6 August 2018

Our Ref: 172453

RE: Development Application – Victoria Cross Over Station Development (SSD 8874)

**Figure 8:** Existing Sydney Water DBYD stormwater assets  
Source: DBYD, 2017

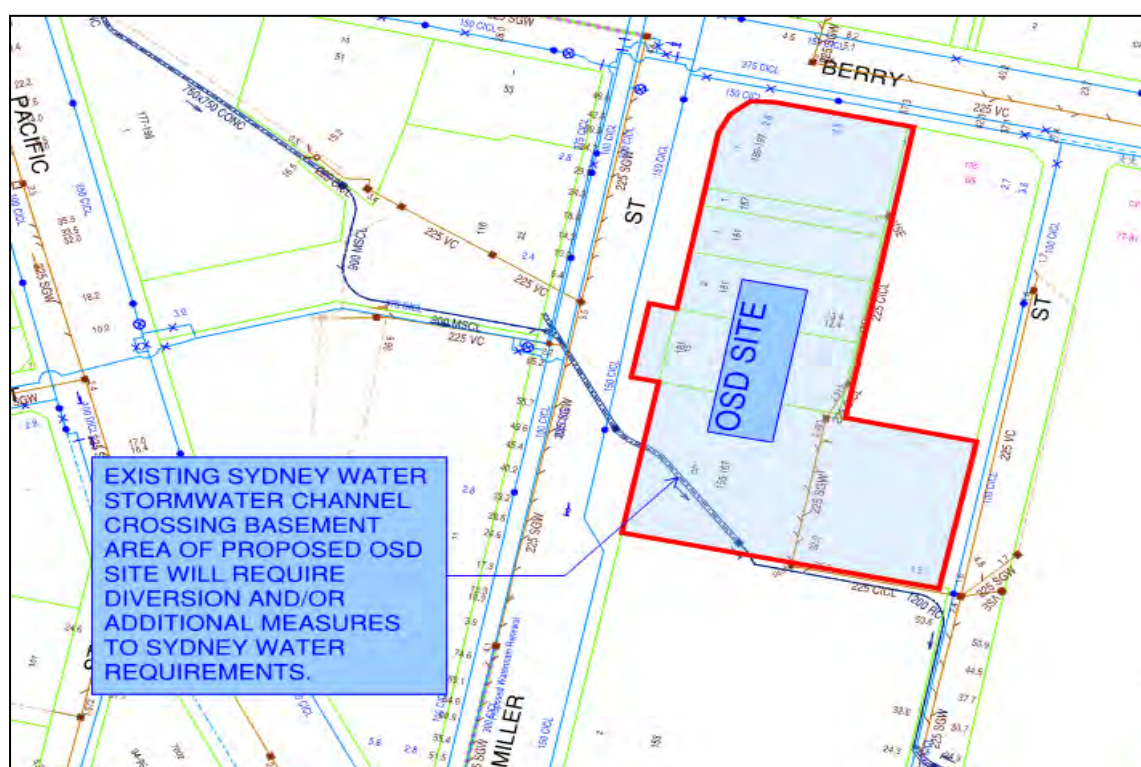
Sydney Water is aware of the proposed redevelopment and the proposal must meet Sydney Water's building over and adjacent to the stormwater assets requirements.

- No building or permanent structure is to be constructed over Sydney Water stormwater channels / pipes or within **1m** from the outside wall of the stormwater asset. Permanent structures include (but are not limited to) basement car park, hanging balcony, roof eaves, hanging stairs, stormwater pits, stormwater pipes, elevated driveway, basement access or similar structures. This clearance requirement would apply for unlimited depth and height.

**Figure 13:** Indicative trunk drainage diversion.

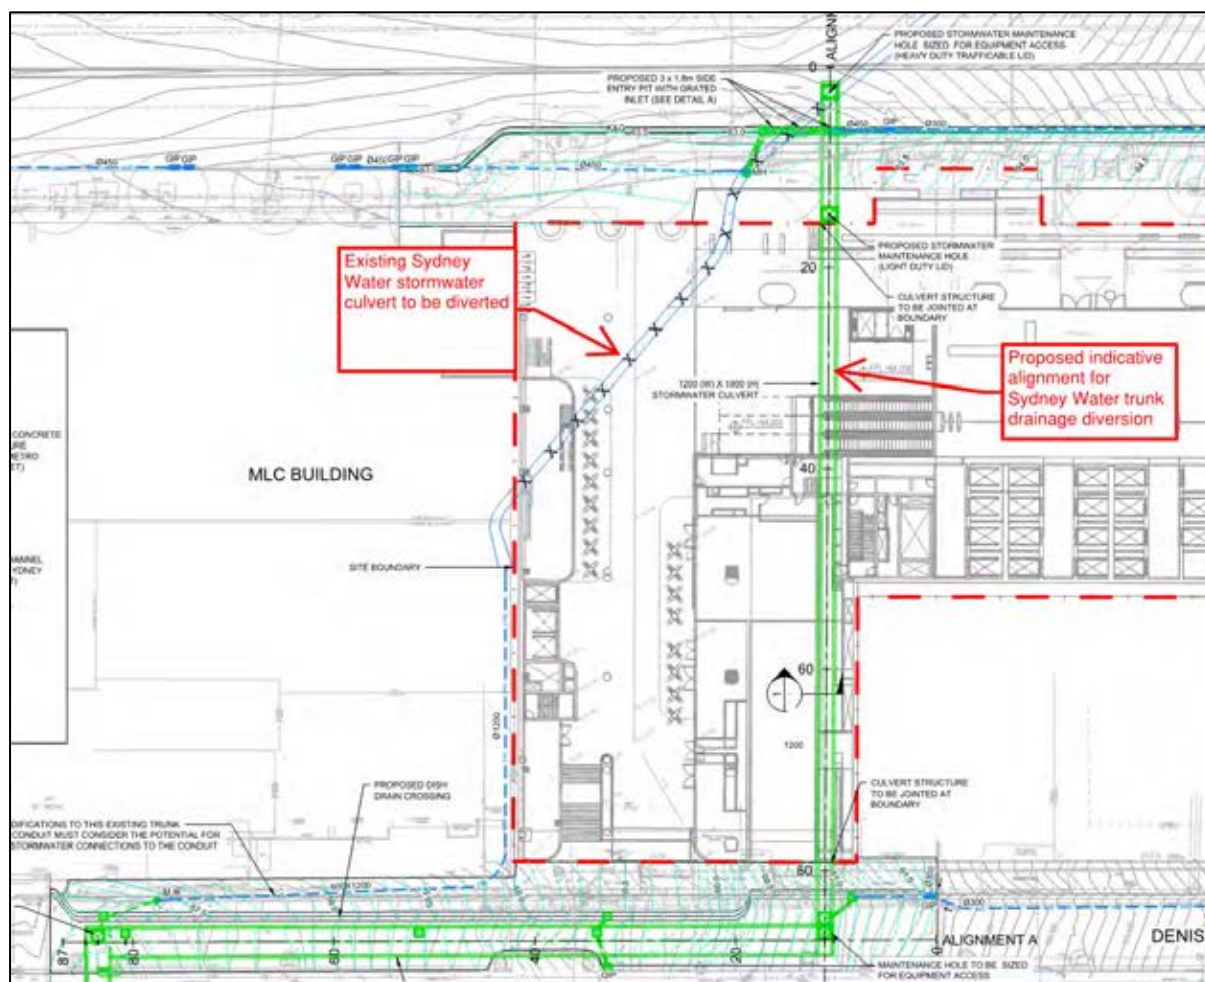
- An elevated // cross-section drawings must be submitted to ensure that the proposed buildings and permanent structures are 1m away from the outside face of the stormwater channel and below the line of influence.

- The Structural integrity of the new assets must not be compromised in future and it must be independent of any proposed building or permanent structures.

Sydney Water recommends that the applicant work closely with Sydney Water during the concept phase of this proposal. As are the current stands, the proposal does not meet Sydney Water's building over and adjacent to the stormwater assets requirements.
